Consultation Response from KC Highways Development Management**2026/90559 Land South of 999 Manchester Road, Linthwaite, Huddersfield, HD7 5LS****Outline application for residential development (one dwelling)****Date Responded: 10/04/26****Responding Officer: M Zenner****Responding Ref: 1-42/22**

RECOMMENDATION: No objection to the proposals subject to the provision of adequate visibility splays and car/cycle parking for the proposed dwelling.

Indicative Site/Block Plan

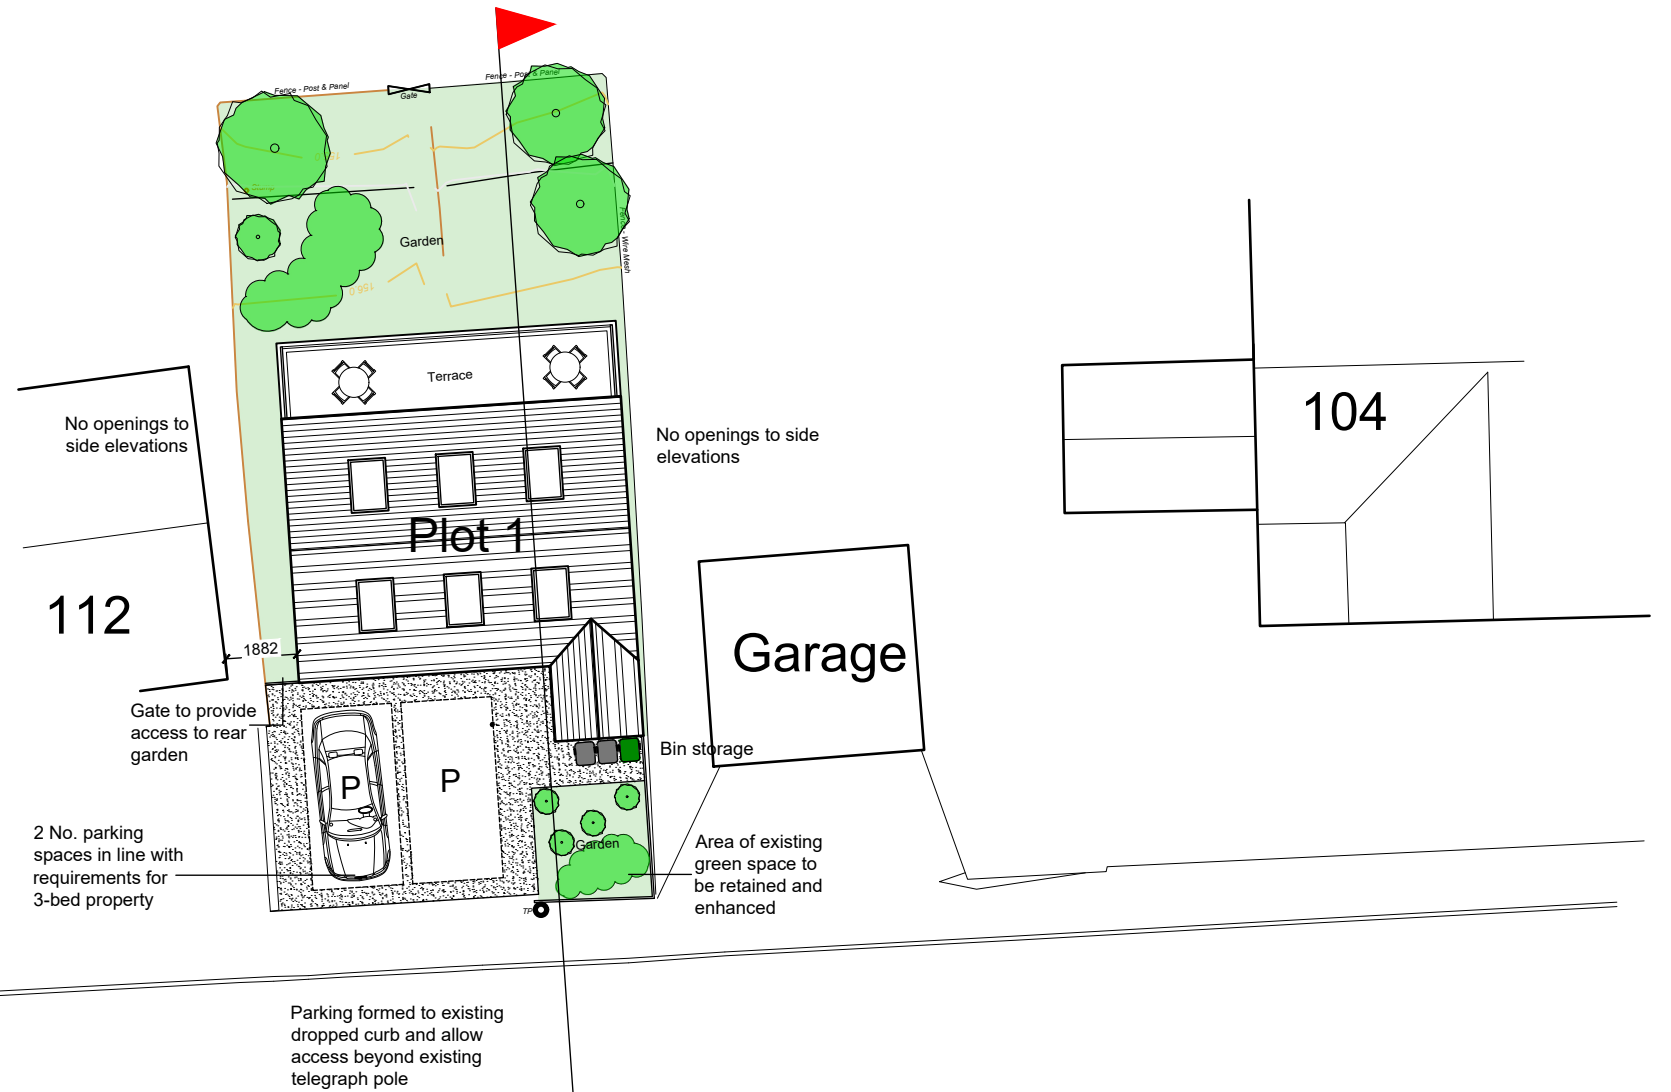
There is an existing telegraph pole located along the frontage of the site which is shown on the submitted plans.

The submitted design and access statement and plans detail the dwelling as a 3 bedroom dwelling with two car parking spaces and a cycle parking space. However, as the proposal is for outline permission these elements could change and therefore comments will not be provided on the proposed layout.

Manual for Streets states that drivers need to be able to see obstructions from 2m high down to a point 600mm above the carriageway. The latter dimension is used to ensure small children can be seen. Ideally pedestrian visibility splays of 2m x 2m should be provided at either side of the proposed driveway. The neighbouring boundary wall appears to be higher than 600mm and may impede visibility.

It is not clear from the submitted plan if amendments to the existing dropped kerb would be required, should they be needed the amendments would need to be secured from Kirklees Council in accordance with Section 184 of the Highways Act 1980. Full details of the application process are detailed here: [Dropped kerbs | Kirklees Council](#)

At reserved matters stage, a plan showing pedestrian intervisibility splays of 2m by 2m at the side of the driveway shall be submitted to and approved in writing by the Local Planning Authority. The pedestrian intervisibility splays shall be implemented in accordance with the approved plan and nothing shall be subsequently erected or allowed to grow to a height in excess of 0.6m within the splays.
